KITITAS COUNTY

MEMORANDUM

TO: All Staff
FROM: Public Works Plan Review Team
DATE: March 26, 2025
SUBJECT: SV-25-00001 Allen

JASON ALLEN
 SITE PLAN

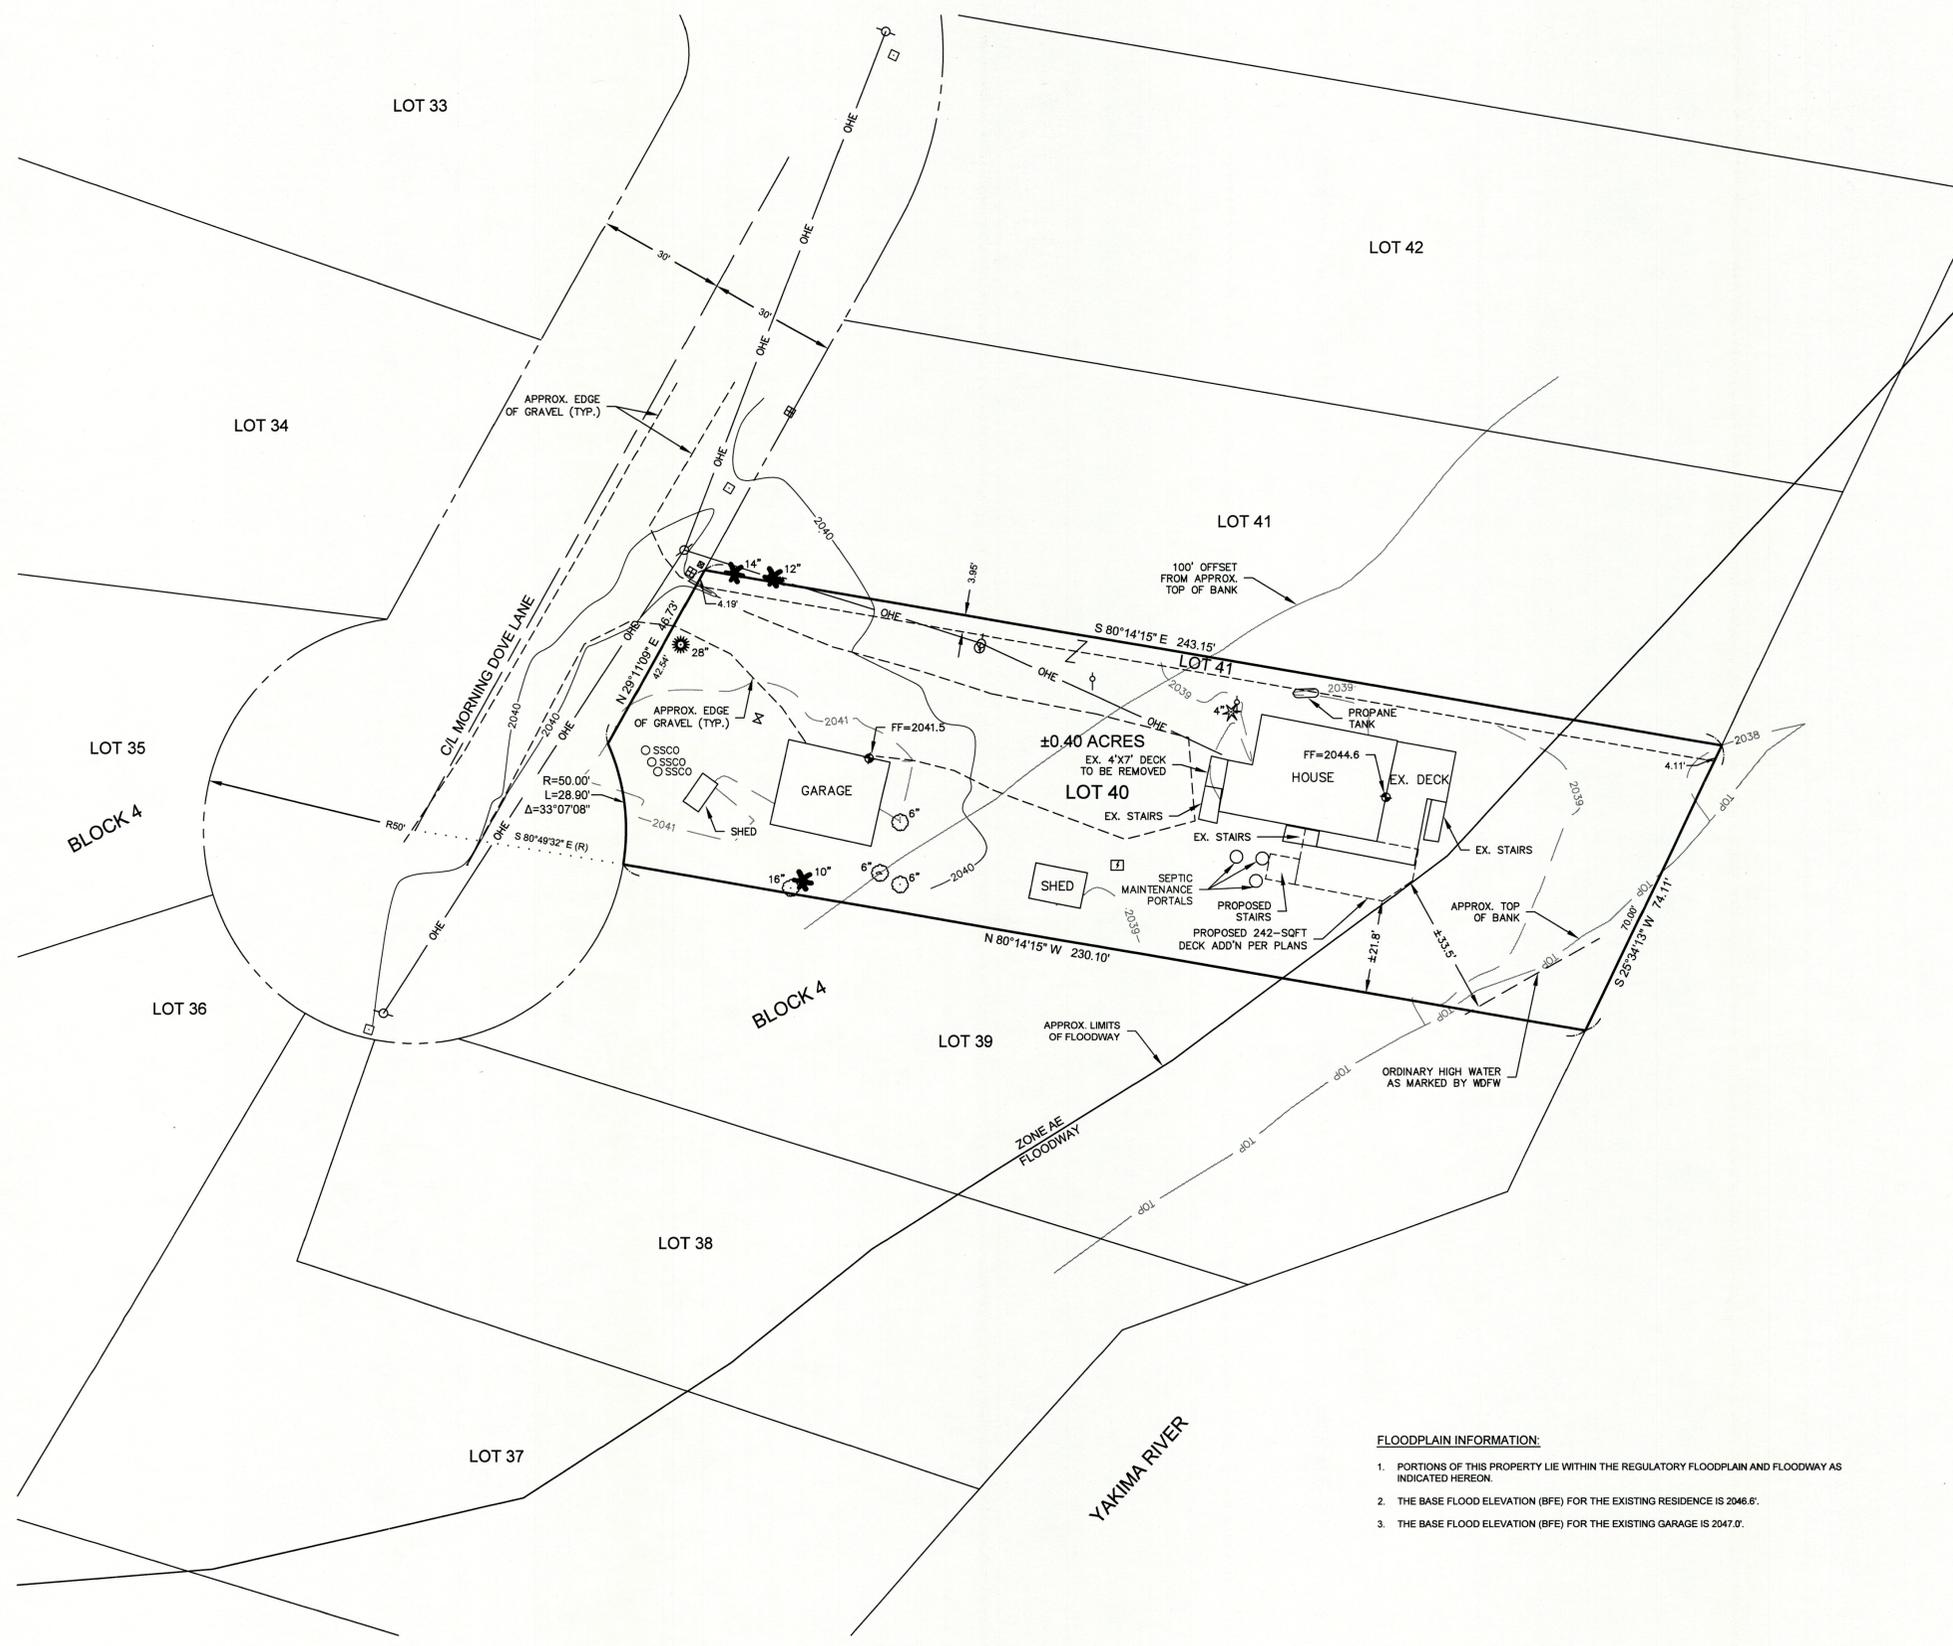
ENGINEERING	Except as exempted in KCC 14.05.060, no grading or filling upon a site involving more than one hundred (100) cubic yards shall be performed without a grading permit from the County Engineer or Public Works designee (KCC 14.05.050). An application for grading in excess of five hundred (500) cubic yards shall be accompanied by an engineered grading plan (KCC 14.05.080). (CP)
FLOOD	<p>A floodplain development application is required for the proposed project. Since this is a remodel/addition to an existing structure a substantial improvement worksheet must also be submitted with the application. If the project is a substantial improvement to the post-FIRM structure, the whole structure must meet current KCC 14.08 Flood Damage Prevention standards.</p> <p>A portion of the parcel is within the floodway. The deck must be outside of the floodway boundary, or a no-rise certificate must be provided that shows the encroachment would not cause any increase to the 100-year flood elevation. Prior to construction it is advised to have a surveyor mark the floodway boundary on site to avoid unintentional encroachment. The floodway boundary being marked on site will be required for the final flood inspection. (SC)</p>
